**EXHIBITION OF ENVIRONMENTAL ASSESSMENTS FOR COMMERCIAL BUILDING C3
(MP11_0044) AND C5 (MP10_0227) BARANGAROO SOUTH**

General Comments on Commercial Building C3 (MP11_0044)

MP11_0044 (Commercial Building C3) - specific comments

LEGEND:

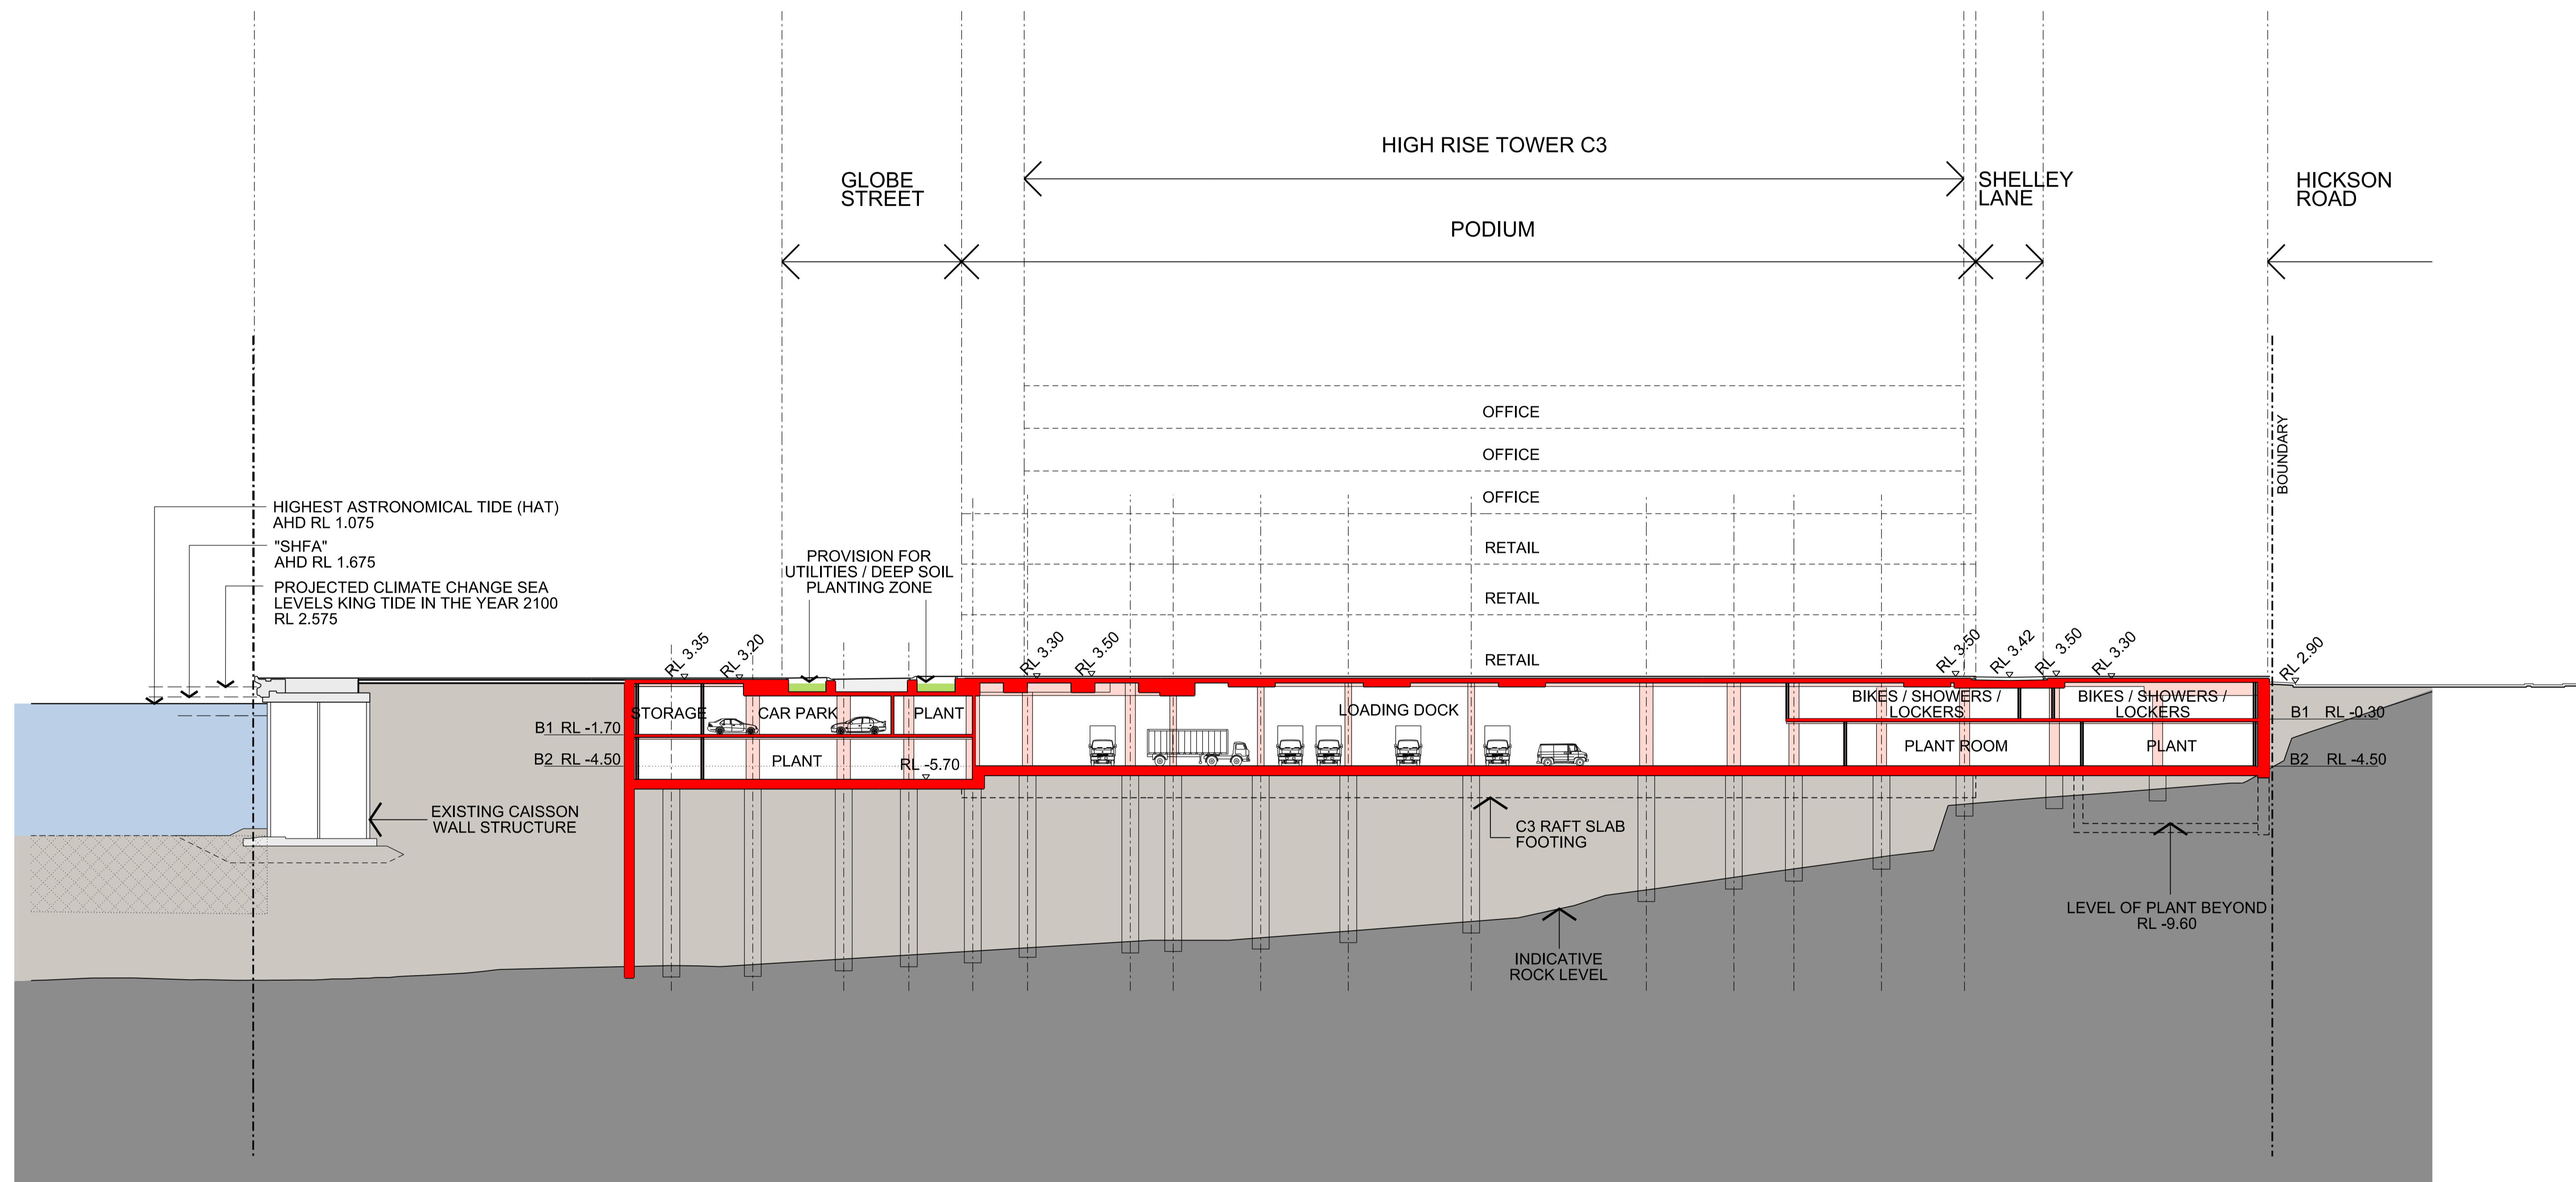
Section 4.10 and Appendix D	There is very little detail on the solution for bicycle parking requirements for the development, and the relationship to adjacent development. It appears that there is a single very small shared facility in the basement. The facilities as proposed appear inadequate for the stated number of bicycle spaces. There is no commensurate provision of facilities for	More details are required on the strategy for bicycle access and facilities. The proponent should address the long term bicycle parking requirements.

cyclists within the building floor plates, or explanation and scoping of facility requirements. There are no details on bicycle access from the adjoining street networks. The maps provided in the supplementary TMAP are general in nature.	Appendix A: Plans	Allocation of staff change facilities within the building's basement appear to be inadequate. Based on the drawings provided, and comparing C3, C4 and C5 indicative basement layouts. A single common staff change facility is provided under C4. This is considered inadequate if this is to service the stated 1,000 plus spaces allocated for bicycle storage. The locality is not convenient to personnel accessing buildings C3 or C5. Note: The building floor plans do not appear to contain any shower facilities in any of the tenancy floors.	Section 5.27 T Appendix The Construction TMP should include consideration of Wynyard Walk, particularly in relation to the reduced road capacity on Napoleon and Margaret Streets. The cumulative impacts of Wynyard Walk have not been identified or considered. The statement that there are no other major construction projects within the vicinity of Barangaroo known at this point in time is incorrect.	Appendix T The Construction Transport Management Plan needs to be amended to reflect comments and updates submitted to Lend Lease on the s75V modifications for Commercial Building C4 and the Basement Excavation and Car parking. Key issues raised include: • Update figures showing vehicle access to site • Resolution of Napoleon Street intersection with RMS.	Appendix T Developer to ensure that issues are addressed in the CTMP to be approved prior to issue of construction certificate Developer to consult with Transport for NSW regarding the CTMP prior to issue of construction certificate Developer to ensure that issues are addressed in the CTMP to be approved prior to issue of construction certificate Developer to consult with Transport for NSW regarding the CTMP prior to issue of construction certificate Developer to ensure that issues are addressed in the CTMP to be approved prior to issue of construction certificate Developer to ensure that issues are addressed in the CTMP to be approved prior to issue of construction certificate
